Application for a non-material amendment following a grant of planning permission.

Number	31
Suffix	
Property name	Mulberry View
Address line 1	West Front Road
Address line 2	
Address line 3	
Town/city	Pagham
Postcode	PO21 4SZ
Description of site location must be completed if postcode is not known:	
Easting (x)	488954
Northing (y)	97102

Detached single garage	
Reference number:	P/121/20/HH
Date of decision	11/02/2021

102 BLOCK PLAN - AS PROPOSED
Scale: 1:500

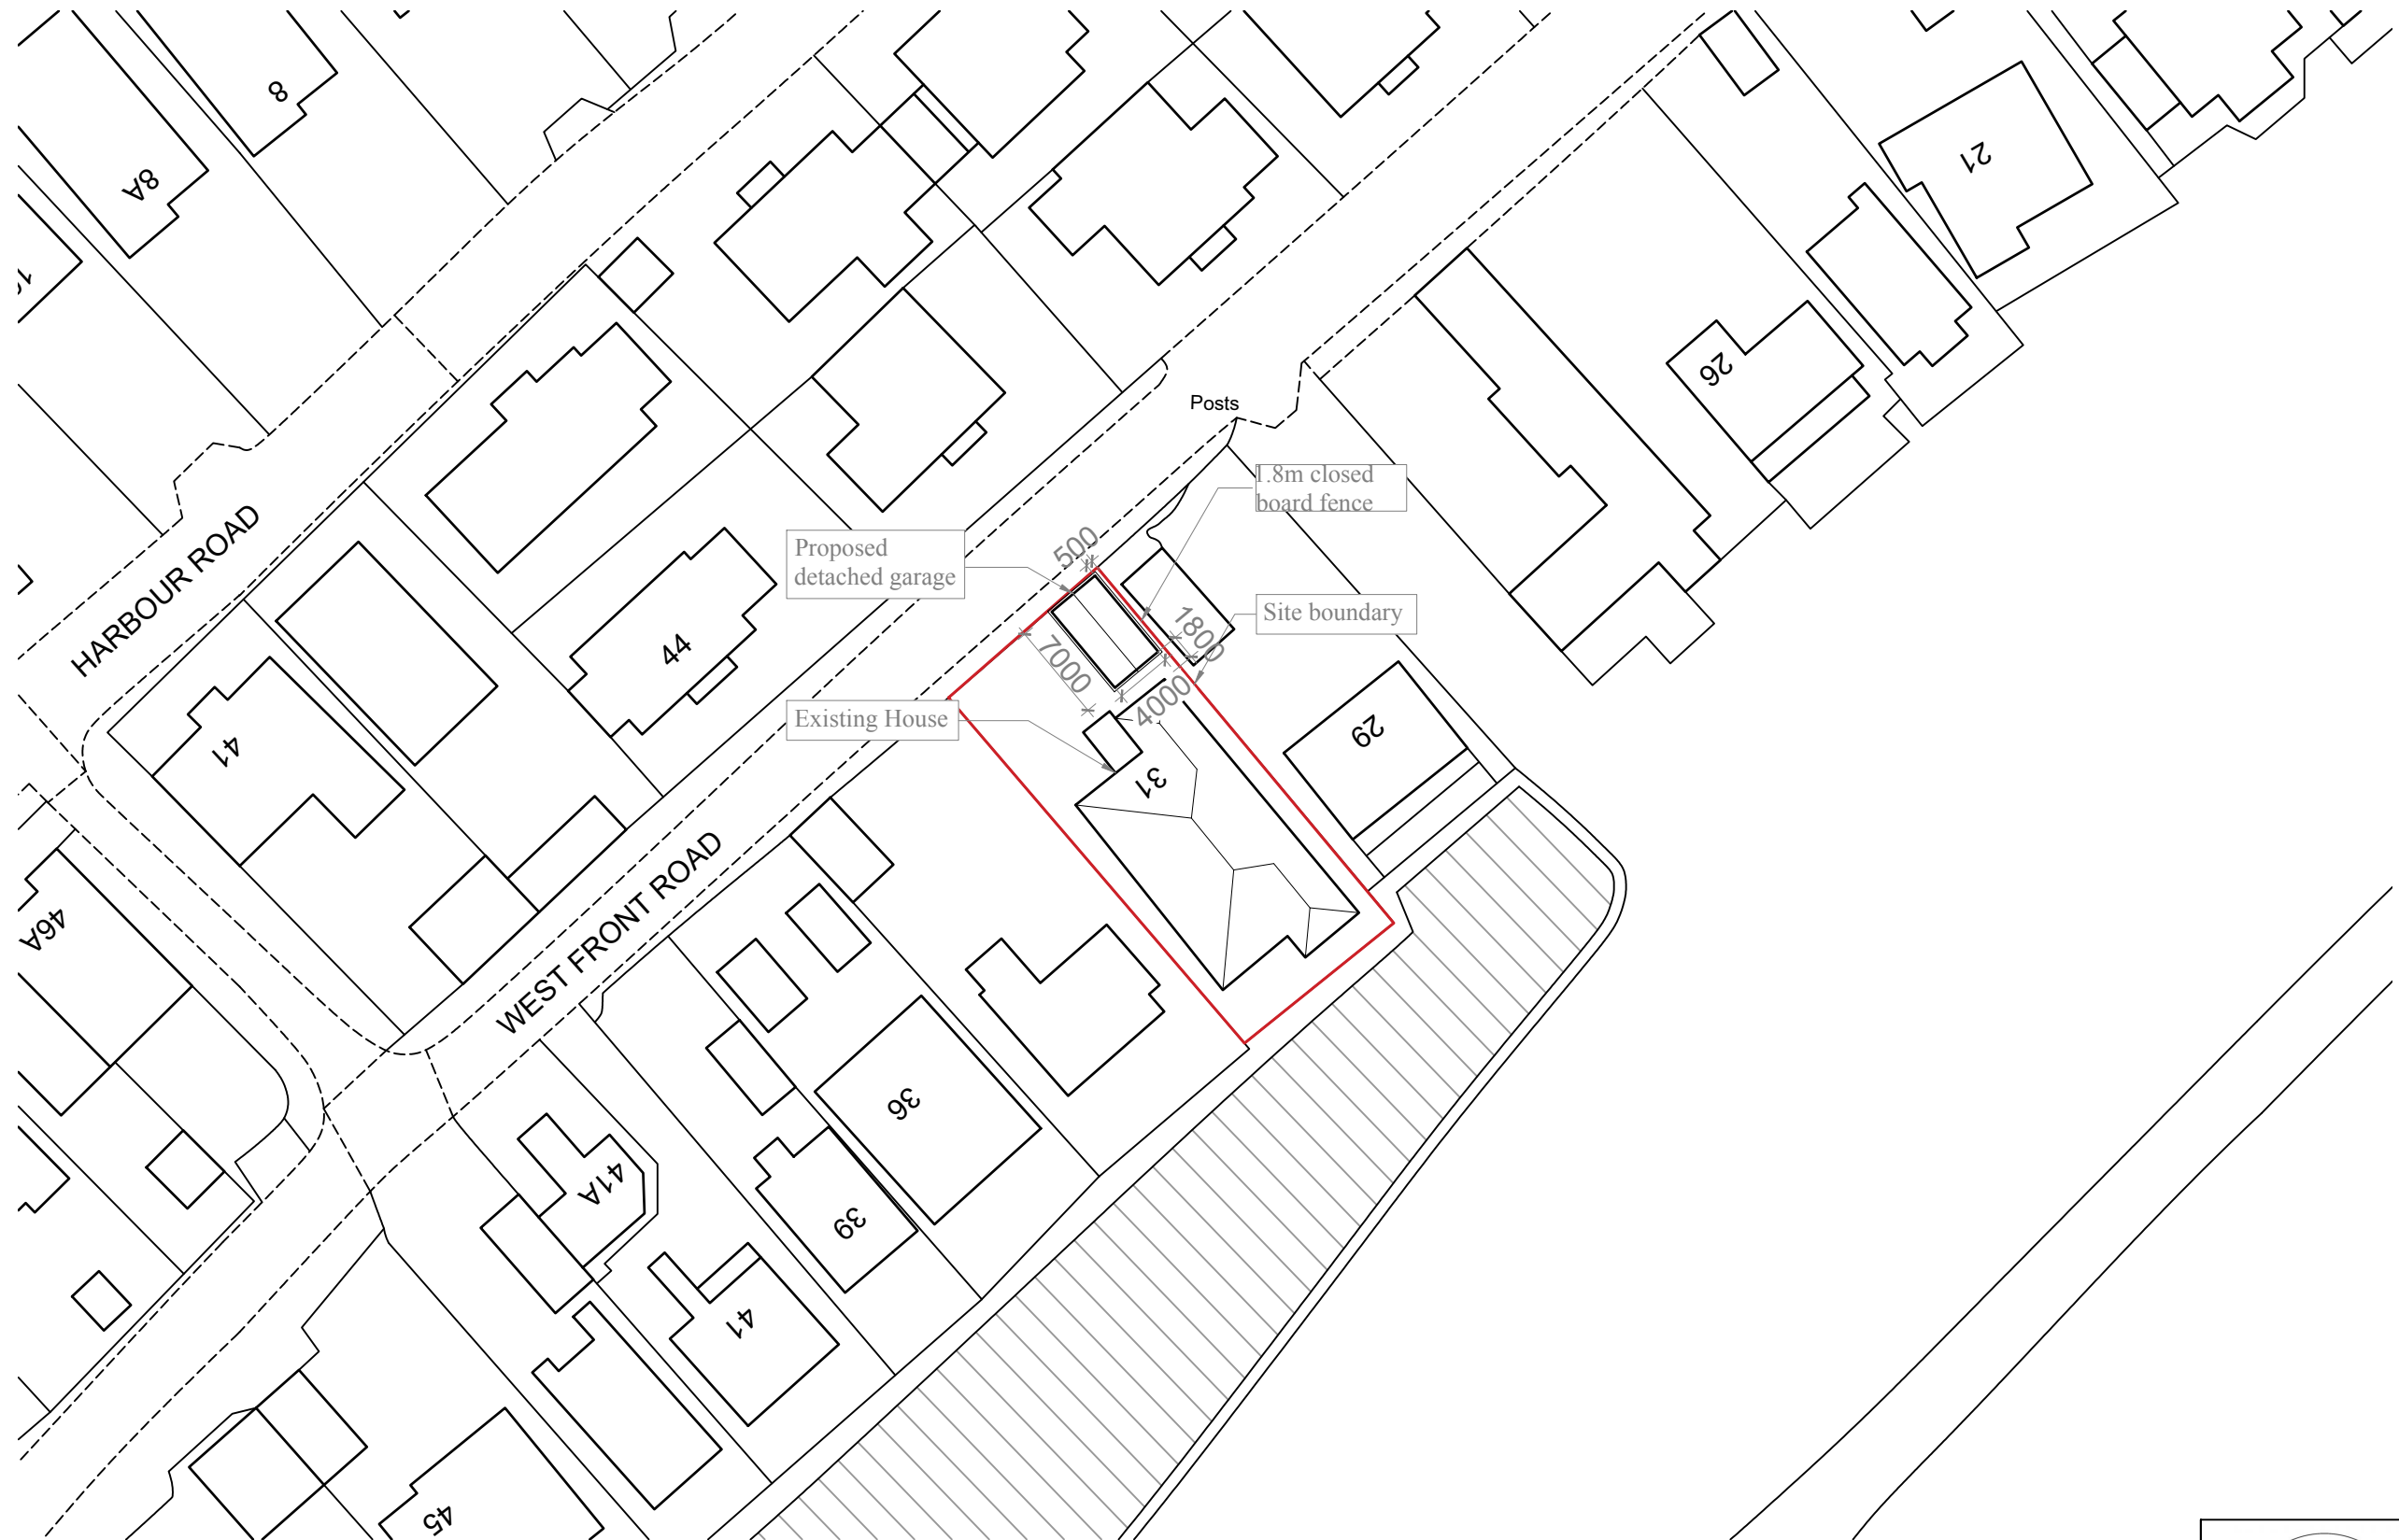
We are making this amendment due to complications with respect to the size of the previously proposed building and its proximity to an existing private drain (manhole). It is considered that the footings and flank wall of the current proposal would interfere with the existing manhole and require a complicated, engineered solution to mitigate this. In proposing a single skin brick construction we are eliminating the need to provide additional structural support to the flank walls and in doing so creating a further separation from the manhole. We intend to use the consented single garage at no.47 West Front Road as a precedent for the revised scheme.

110 102 BLOC PLAN A
110 110 GF RF PLAN A
110 120 ELEV PLAN A
110 121 STREET ELEV PLAN A
110 122 STREET ELEV PLAN A

120 ELEVATIONS - AS PROPOSED
Scale: 1:50

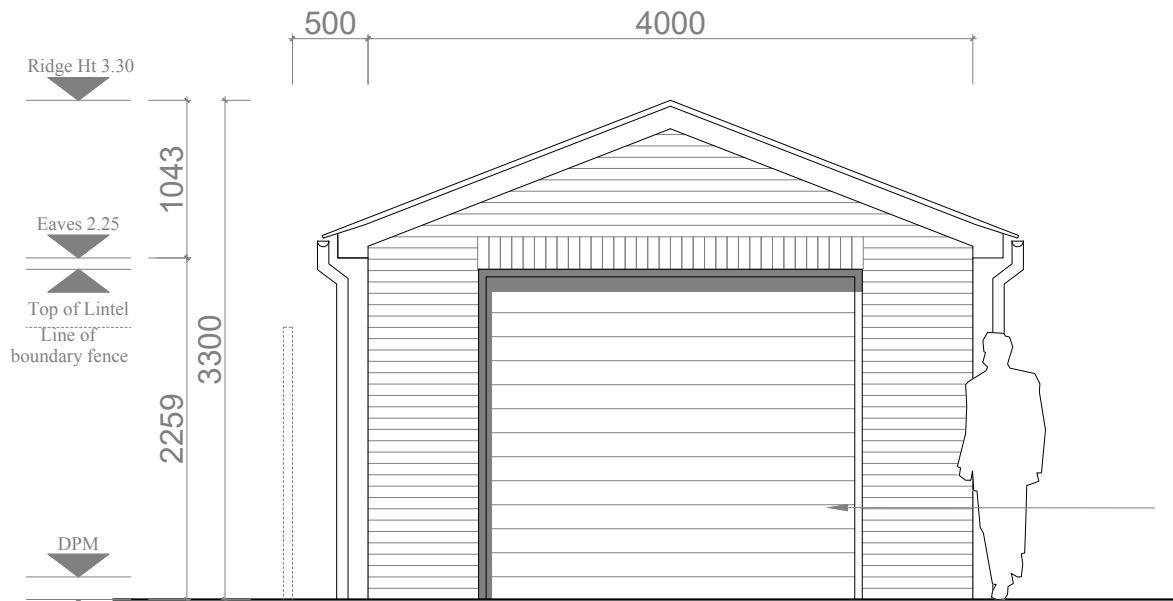
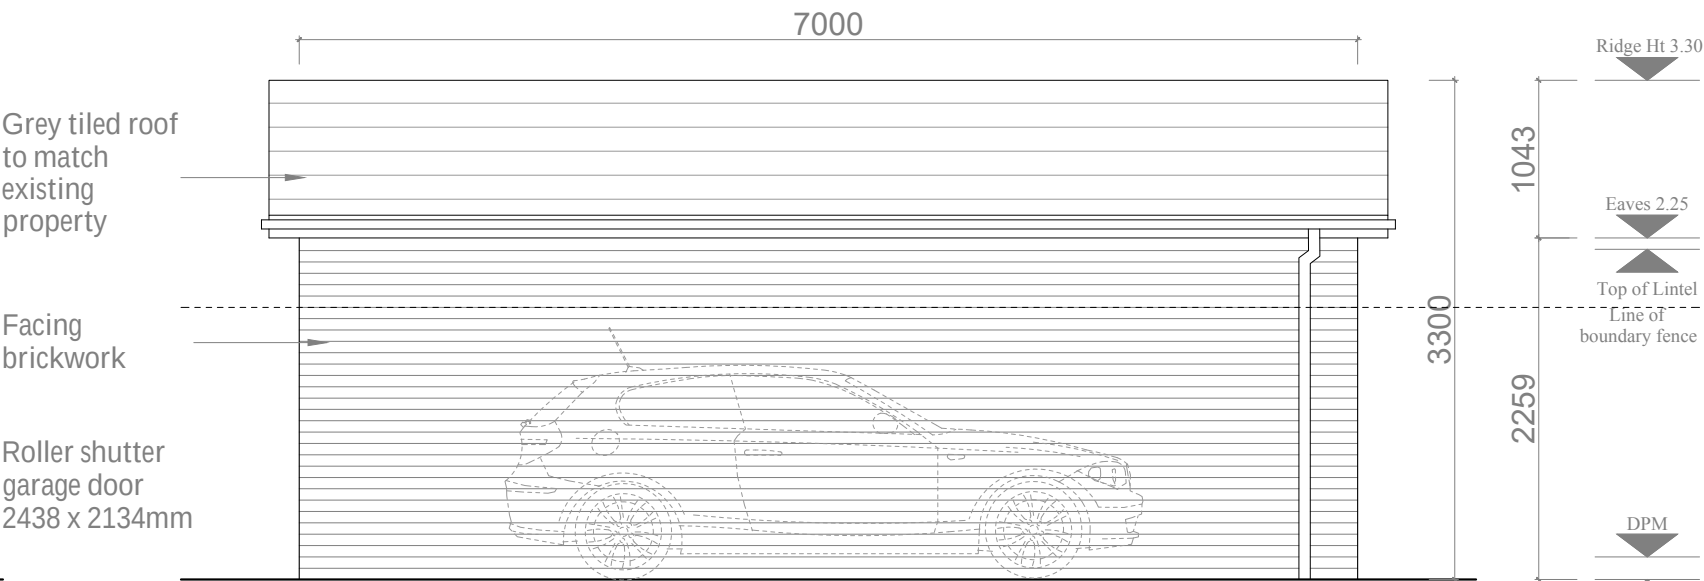
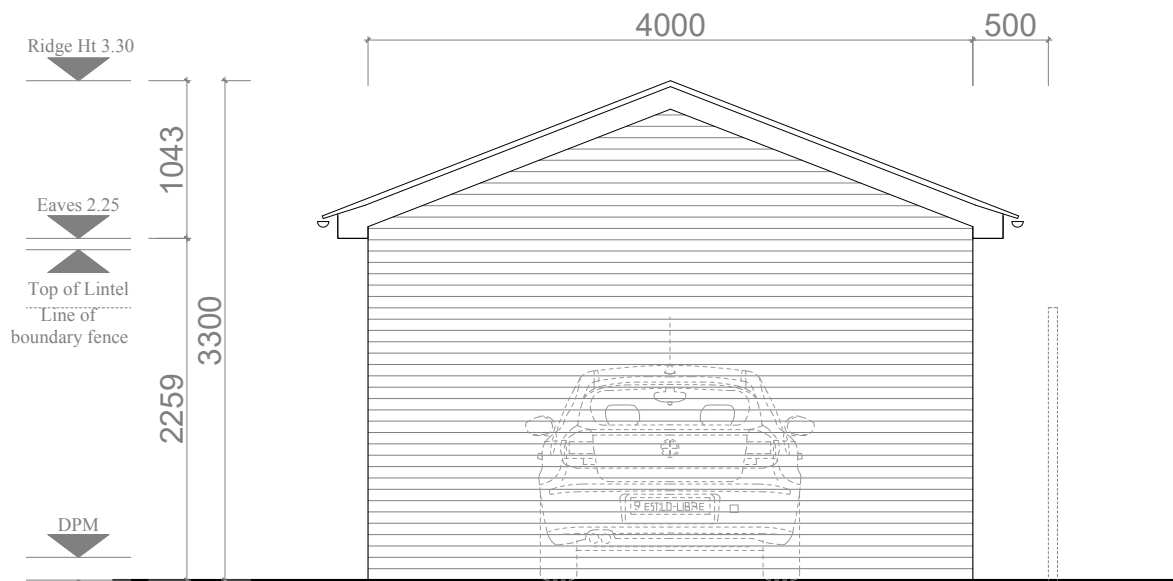
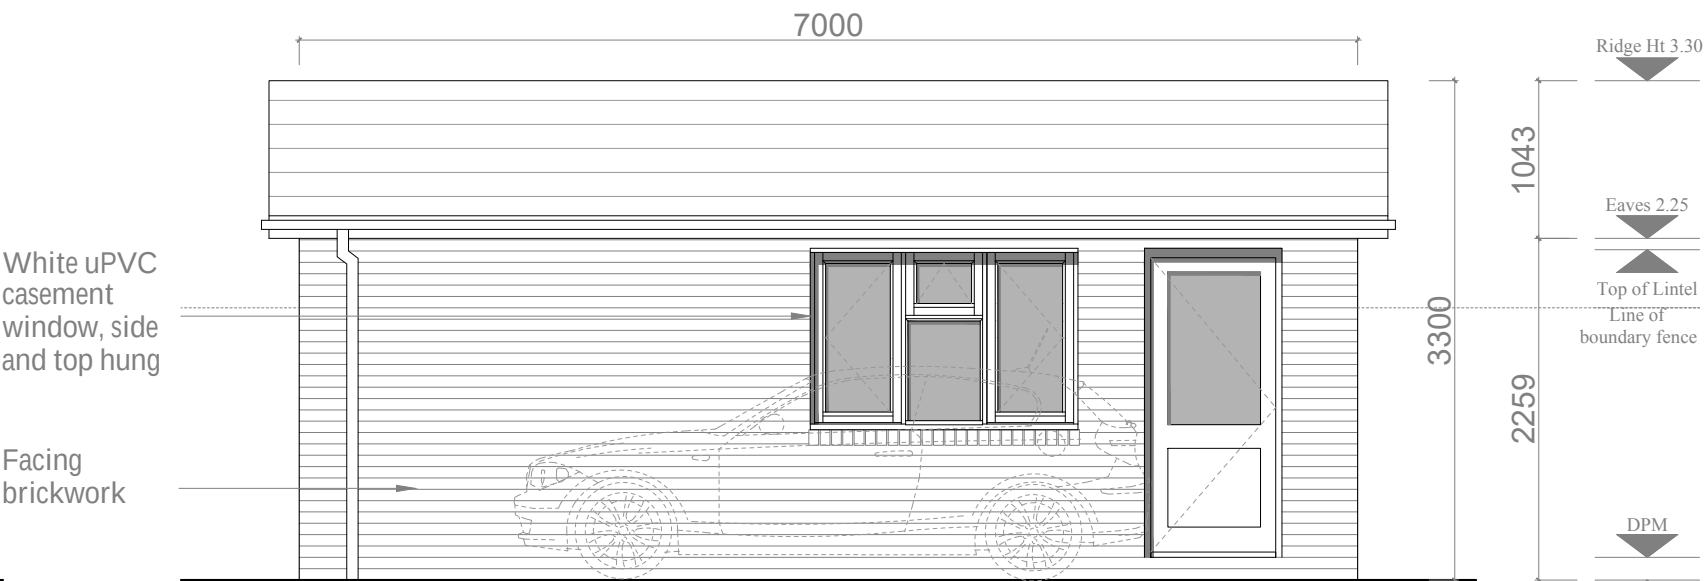
We are proposing to alter the materials used to construct the building. Previously, render and brick quoins finishes had been proposed. We are now looking to construct the building from a single brick skin in line with other buildings in the immediate setting of the site (see no.47 West Front Road). We are also looking to propose a roller shutter door of identical appearance to the previously proposed up and over door. This will in effect be identical but will offer more security.
